From:
Sent: 27 November 2024 00:41
To: DC Admin
Subject: Objection to planning application 2024/92983

We object to plan application 2024/92983 at 3 Stainecross Avenue, Huddersfield, HD4 5HZ, because it is similar to the previous retrospective application that was refused for illegal building, being an eyesore, and devaluing neighbouring properties.

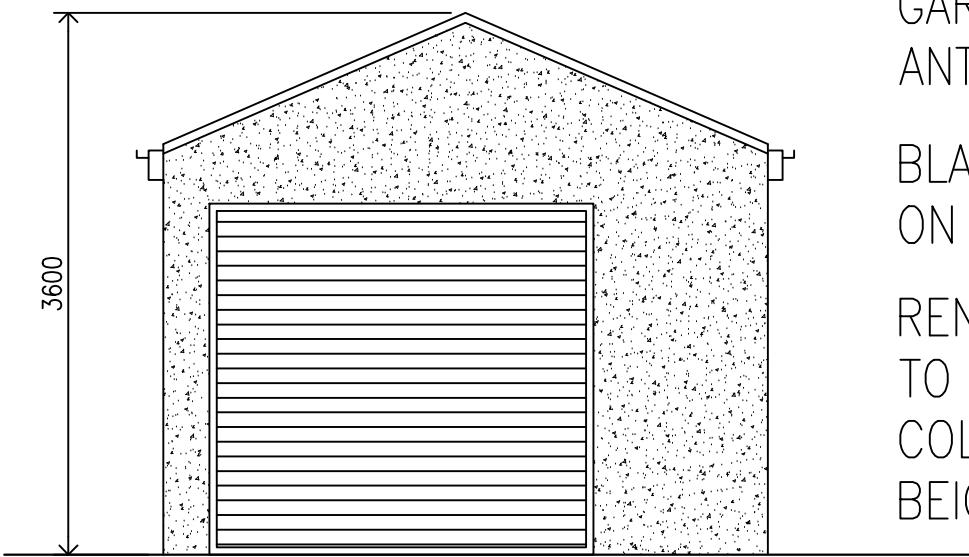
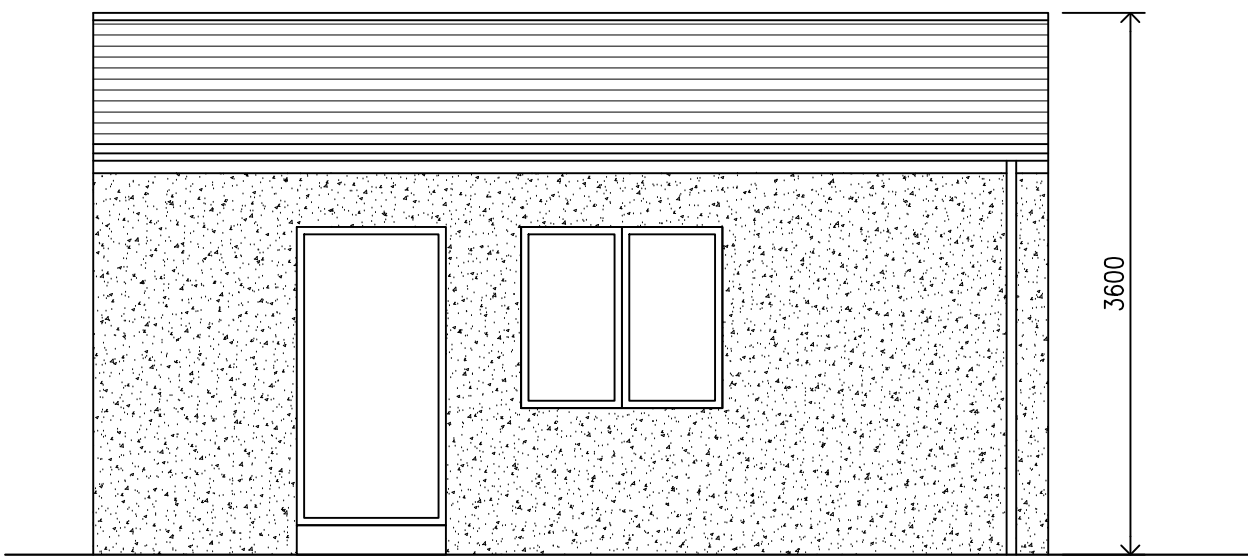
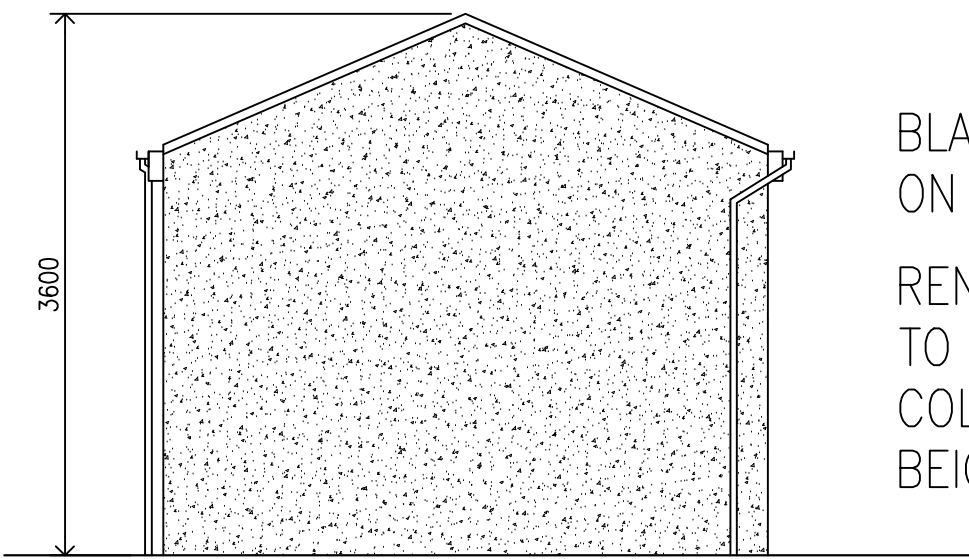
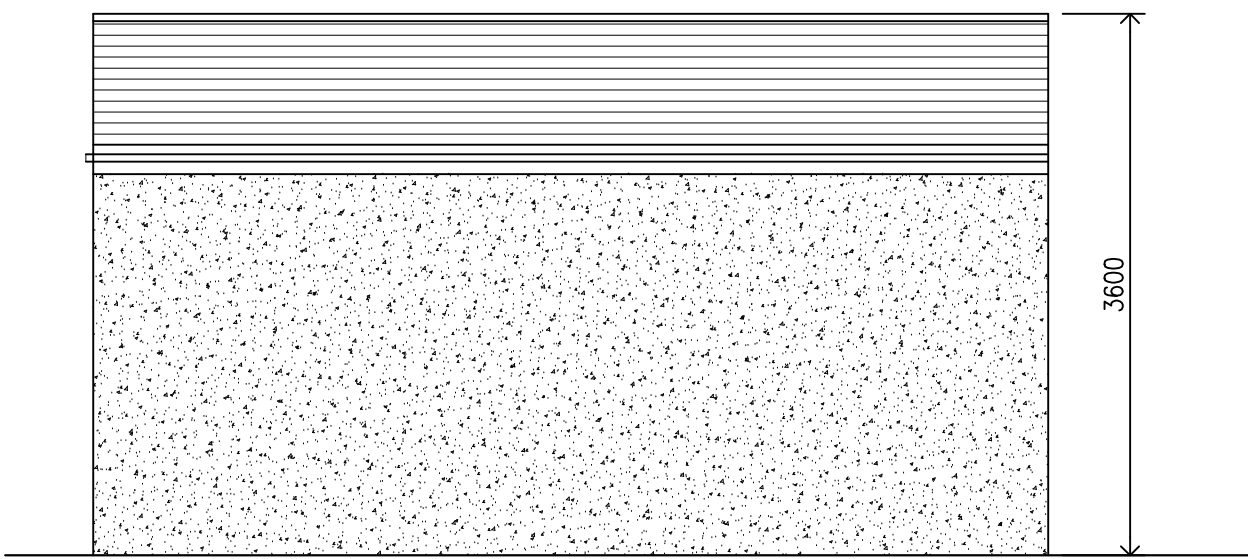
The original garage as seen on google maps street view, had a flat roof, it was supposed to be relocated further back in the garden, all rain water was kept on the 3 Stainecross Ave side. The previous garage had a separate wall from the shared boundary wall. Dilshad Shad has illegally used the shared boundary wall as a new wall for the new garage, with unsafe shoddy brick work with different low quality breeze blocks. The new dual pitched, open Gable type roof, where the roof crosses the boundary line and where for this past year and currently water flows illegally from this roof into the neighbouring 1 Stainecross Ave Garden. He has not installed guttering, if he did it would also be illegally crossing to the neighbours boundary side, also the guttering there would be higher than 4 metres and if it became blocked, he would have to trespass into the neighbour's garden. Dilshad Shad

Therefore he should not be allowed to have a dual pitched open gable type roof on the garage. He should only be allowed a flat roof, same as the flat roof that was on the original garage. The flat roof kept rain water legally on the 3 Stainecross Ave side.

The new roof illegally crosses the boundary line, where rain water illegally flows into the neighbouring garden.
